**OXFORDSHIRE COUNTY COUNCIL’S RESPONSE TO CONSULTATION  
ON THE FOLLOWING DEVELOPMENT PROPOSAL**

**Application no:** 22/01611/OUT

**Proposal:** Outline planning application for up to 118 no dwellings (all matters reserved except for access) with vehicular access from Oxford Road

**Response Date:** 28/03/2023

Footway Connection – Croxford Gardens
MAC drawing no. 122-TA06

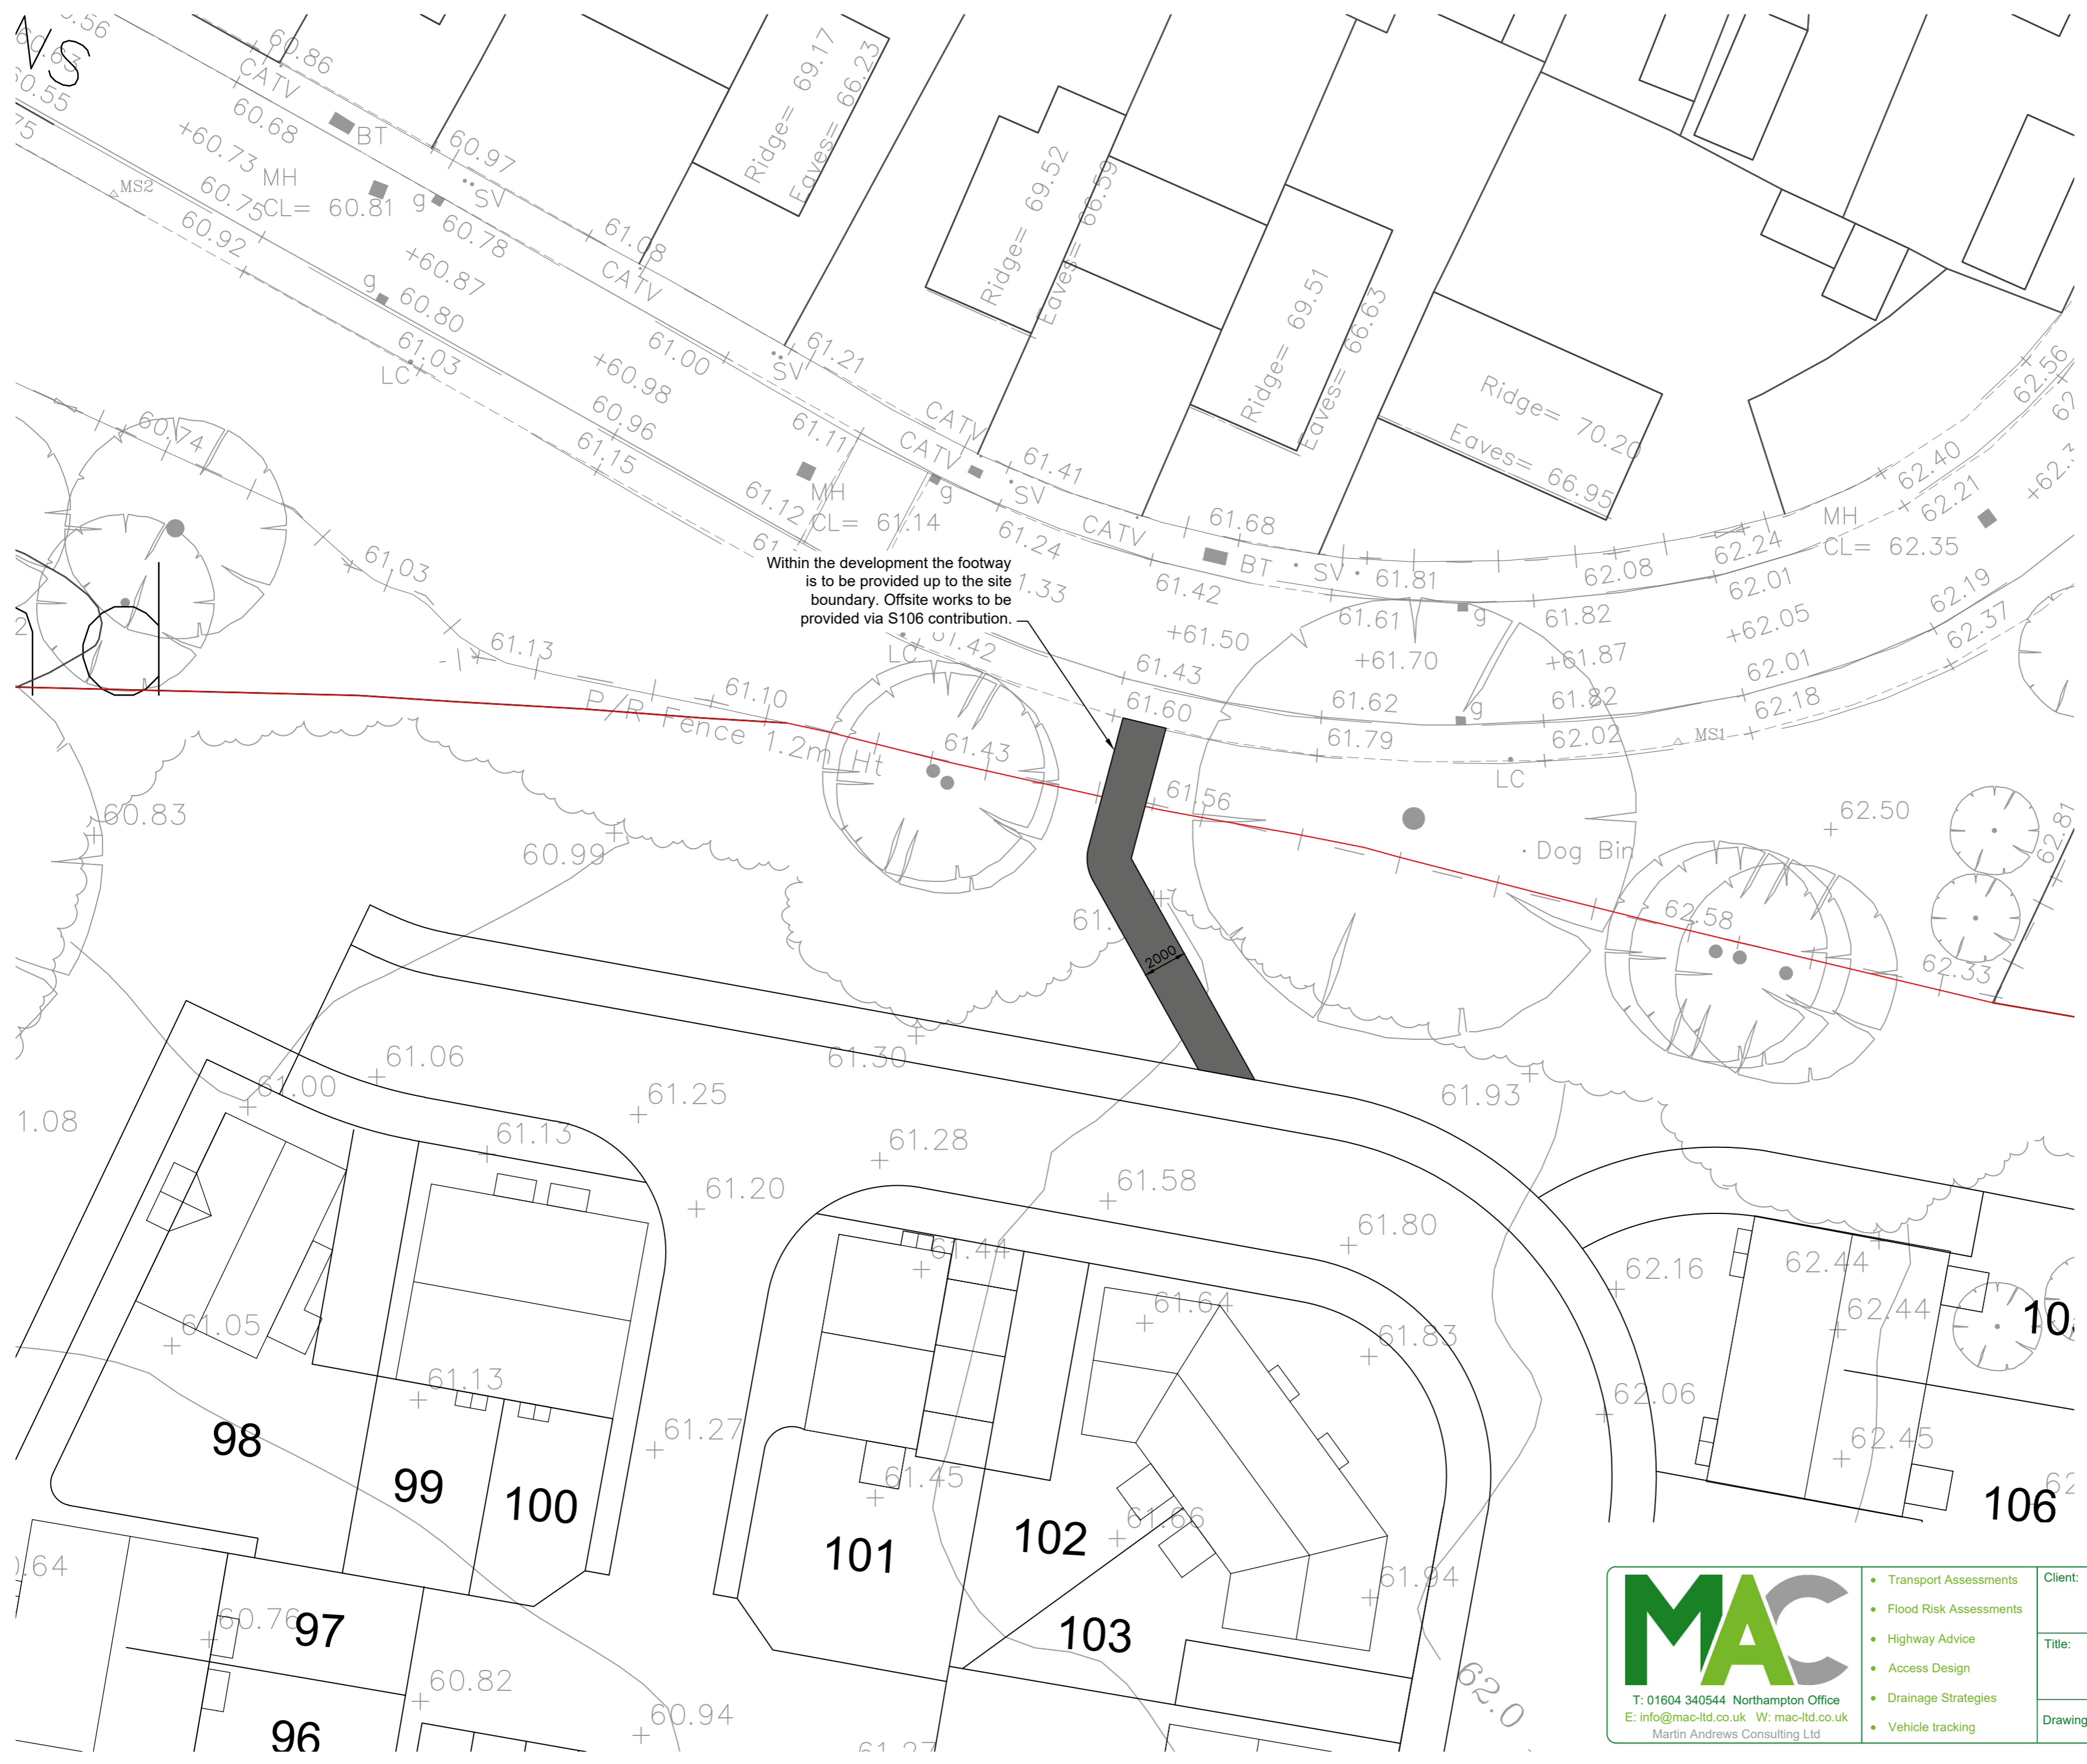
3. Croxford Gardens Footway Connection. The application has shown a willingness to deliver a 2m wide footway connection onto Croxford Gardens to the north of the site right up to the site boundary. A financial contribution is offered for delivery of the extent of footway outside the site (third party land) which shall be secured via a s106 agreement. This is illustrated by *MAC Drawing No: 122-TAG06* within Appendix C of this TN.

This endeavour is appreciated. However, this does not guarantee that this much needed access point shall be secured let alone be delivered. By now, I would have expected the applicant to ascertain from the third-party landowner the possibility of acquiring access here in order to understand with certainty the accessibility of the proposed development.
